From: Contact Centre (CRM) <contact@ribblevalley.gov.uk>
Sent: 10 August 2025 19:12
To: Planning
Subject: Planning Application Comments - 3/2025/0540 FS-Case-738711569

Planning Application Reference No.: 3/2025/0540

Address of Development: Brooklands
Longworth Road
Billington
BB7 9TS

sheet name:
Proposed Second Floor and Roof Plan

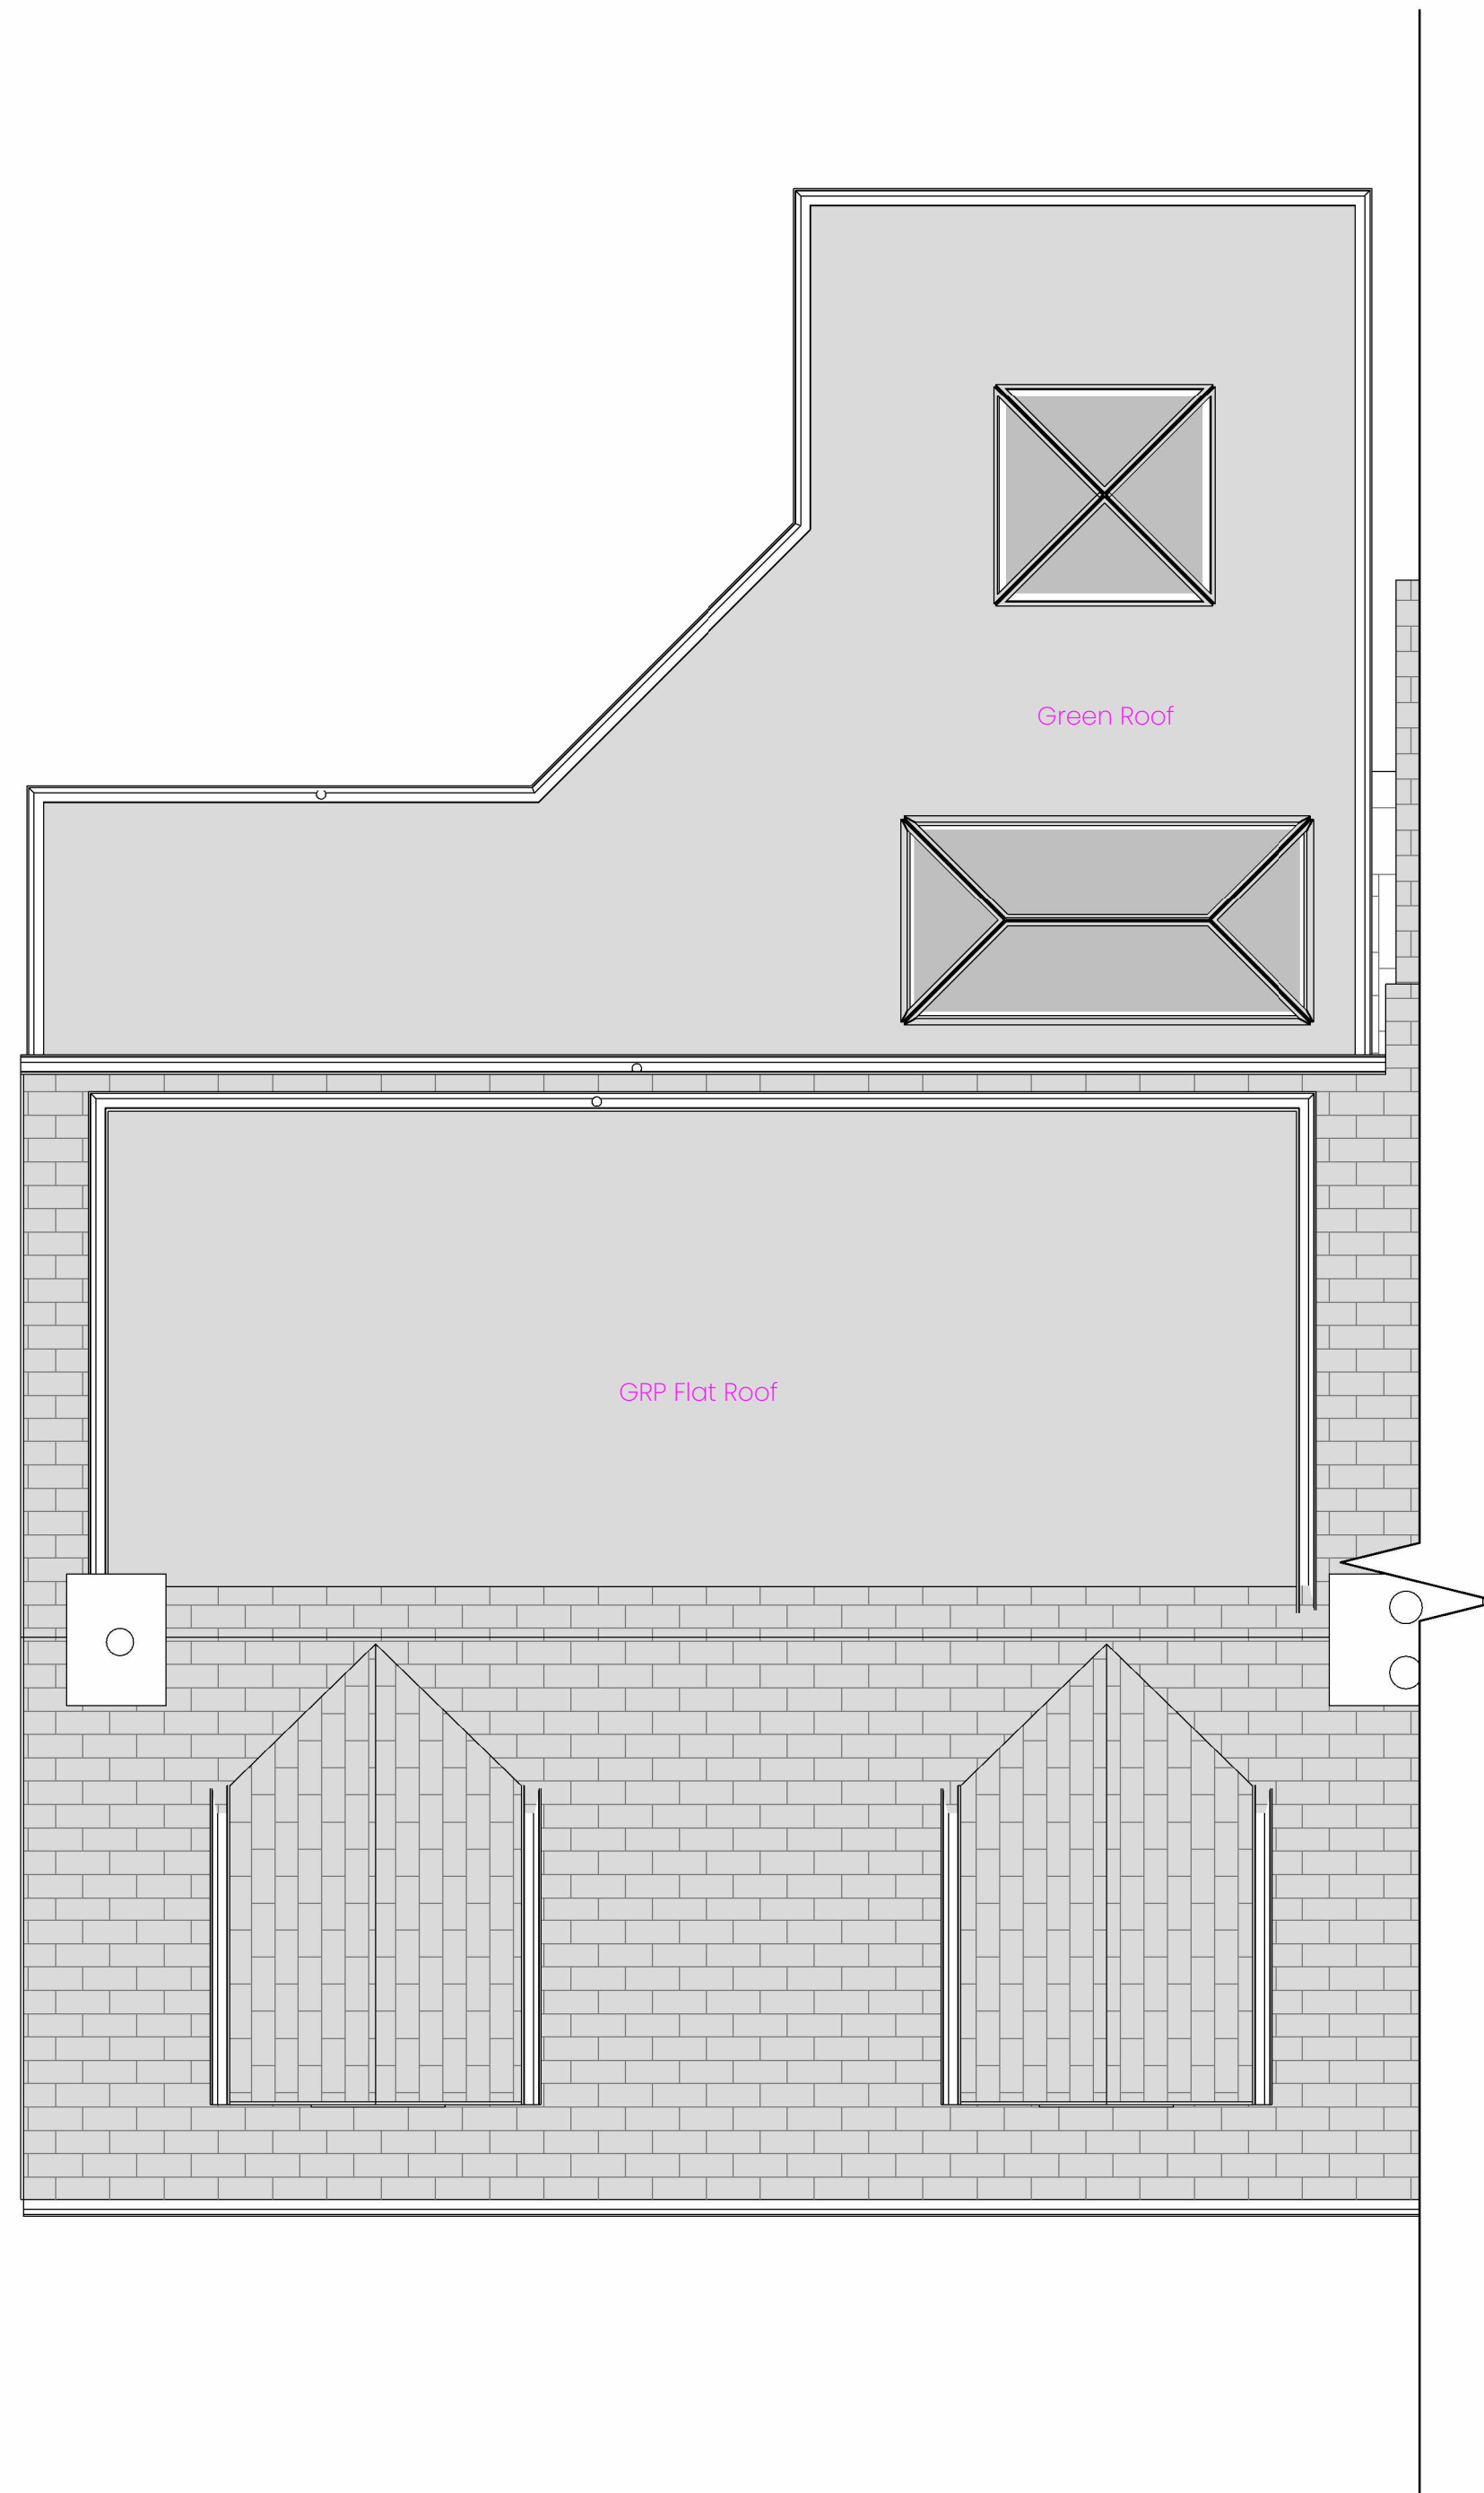
Comments: We objected to the last application because the 2nd floor dormer rear windows

The new plans have not changed that, in fact they include an additional 2nd floor larger dormer window replacing a smaller round one in the original plans.

These 2nd floor dormer windows will take away much of that privacy.
We therefore object more strongly to the new plans.
